CONSTRUCTION DOCUMENTS
MONUMENT STEEL STRUCTURES
 GRADING AND EROSION CONTROL PLAN
 18910 BASE CAMP ROAD
 MONUMENT, COLORADO

SHEET NUMBER
EC
 5 OF #

GEC_v1-redline.pdf Markup Summary

GR

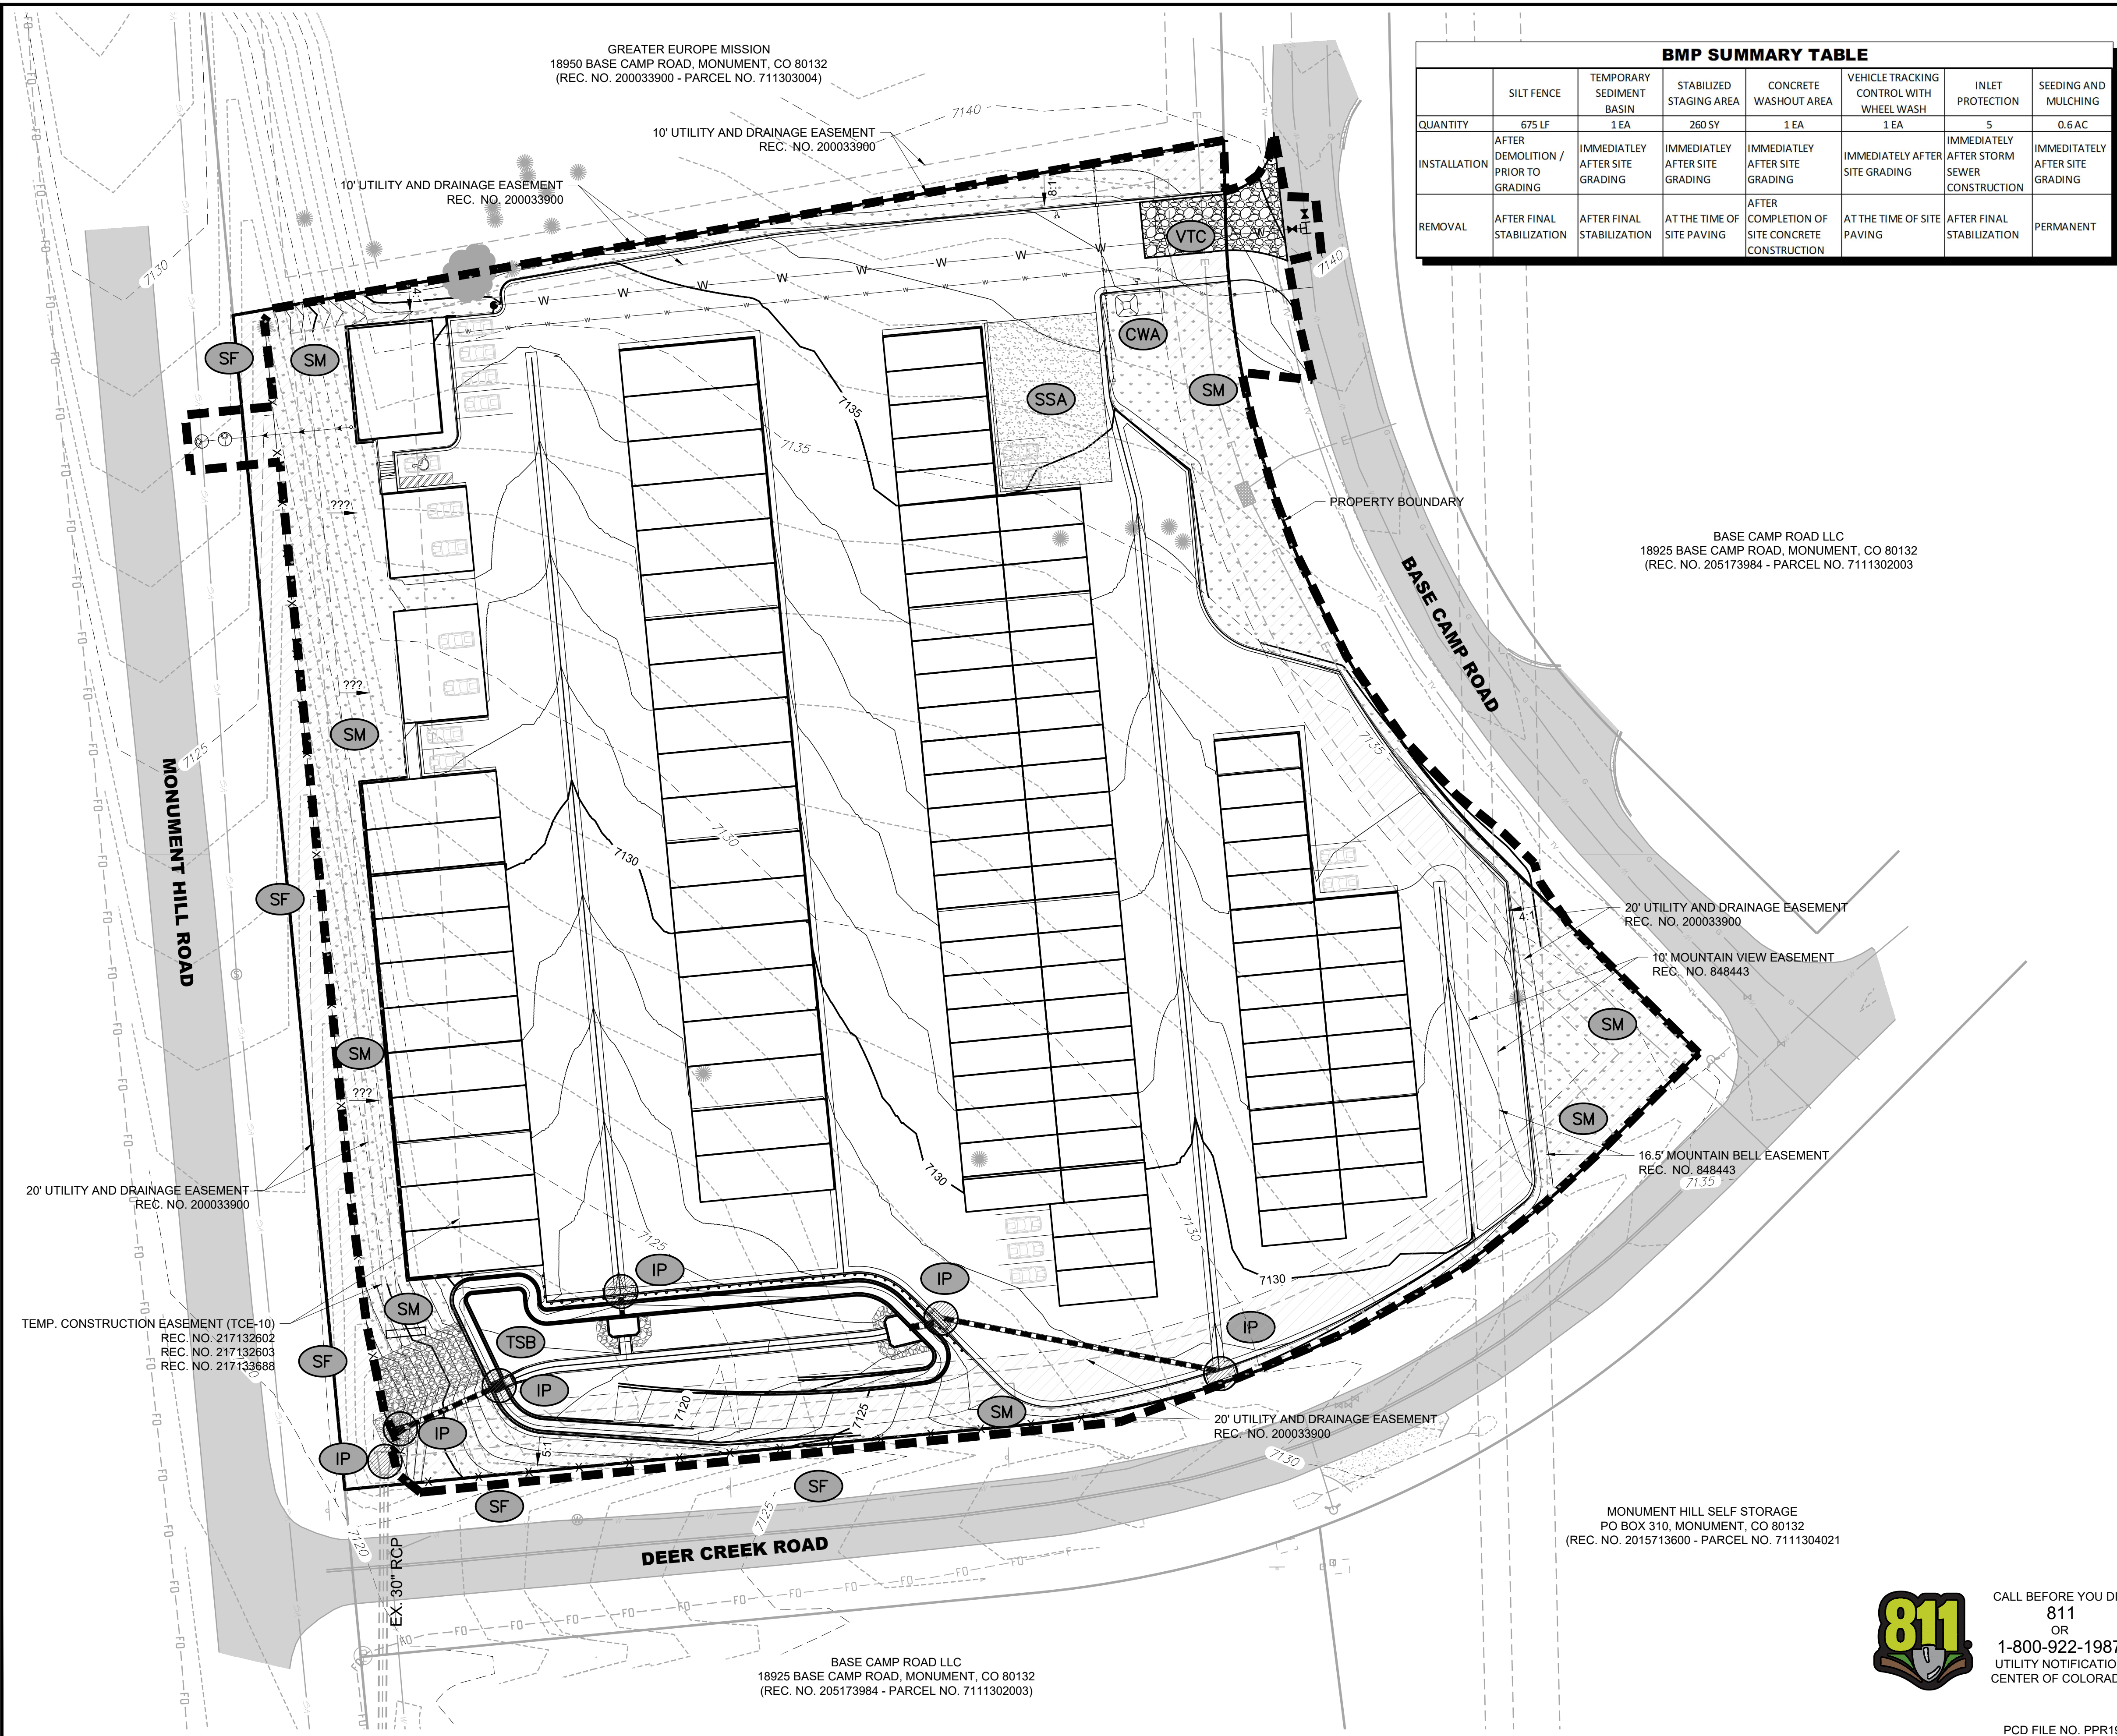
Applicant must obtain permission from the adjacent property for off-site grading and for the permanent riprap (permanent easement) located on the adjacent property.
Upload a written document with the adjacent properties approval. GEC plans will not be approved as designed without approval from the adjacent owner.

Extend riprap to the opposite bank.

provide slope label

Provide a typical cross section detail of the cross pan, riprap swale and emergency overflow.
Label the length, width, depth, and size/type for the ripraps.

Label property line

Label Finished Floor Elevations for each building.

Contact Regional Building Department regarding their criteria with respect to the retaining wall.
1. While the retaining walls are tiered these might still be considered a structural retaining wall requiring building permit since the separation is approximately 4'. Typically the separation of tiered retaining walls are equal to 2x the height of the wall.
2. Additionally, see the pikes peak regional building code RBC105.2 item 5. A building permit may be required since the retaining wall may be supporting a surcharge from a structure even if the retaining wall is less than 4 feet in height.

Provide wall spot elevations and retaining wall details.
If the retaining walls include horizontal anchors, these anchors shall not encroach into the ROW.

Revise grading to not extend into the right of way. Roadside ditch to remain.

Coordinate with EPC Department of Public Works to ensure grading along Monument Hill Road and Deer Creek Road matches their roadway design. Contact Alissa Werre at 719-520-6873 or alissawerre@elpasoco.com

Identify as Temporary Sediment Pond during construction. Provide TSP detail.

Provide riprap at the FES

label pipe size

Label trickle channel slope and pond bottom slope towards the trickle channel

Provide slope label of the maintenance ramp and identify the surface material

FYI: Consider installing a fence or guard rail along the top of retaining wall for safety.

Provide inlet and pipe construction details. (size, material, inverts, rims, etc)
